Our Ref: P/43/11/NMA

P/43/11/NMA – Application for a Non-Material Amendment following a grant of planning permission P/87/08 for the addition of 2 velux windows in the bungalow and siting of garage building (as constructed) nearer to the rear boundary 12 Bridorley Close, Pagham

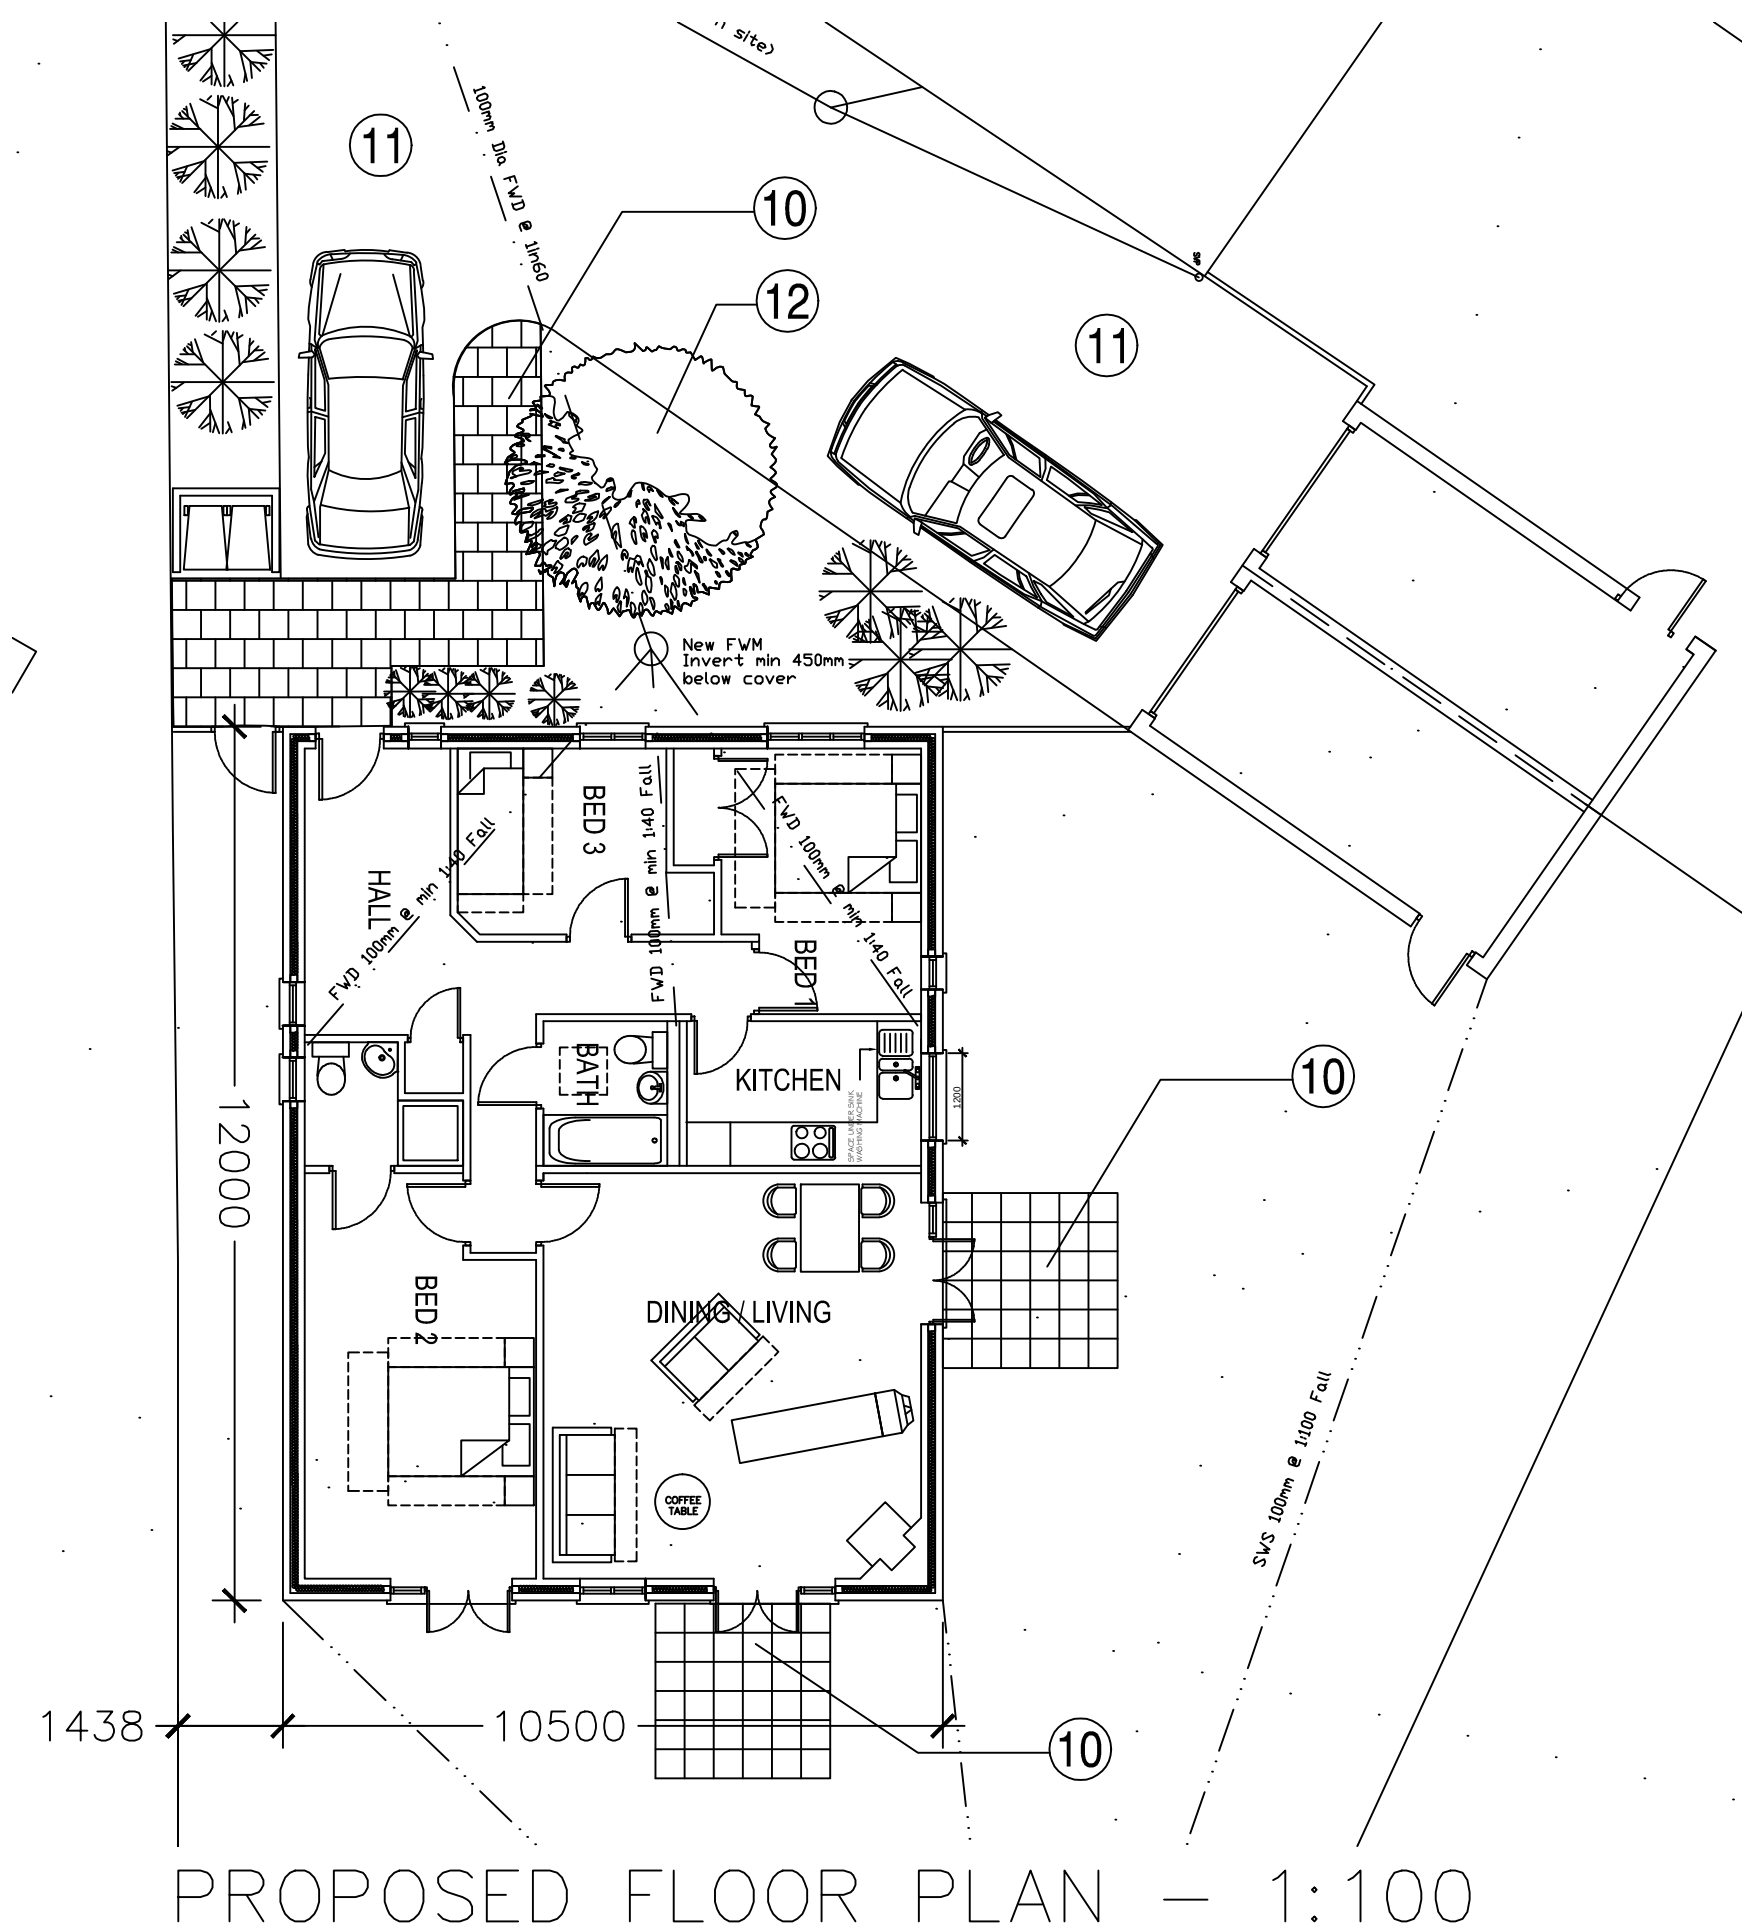
The installation of 2 velux windows within the roof on the north and south side of the bungalow and the siting of the garage building 3m from the rear boundary can be accepted as a Non-Material Amendment as shown on the submitted drawing No. 08-0010/P01-Rev D. This now becomes the approved plan for P/87/08.
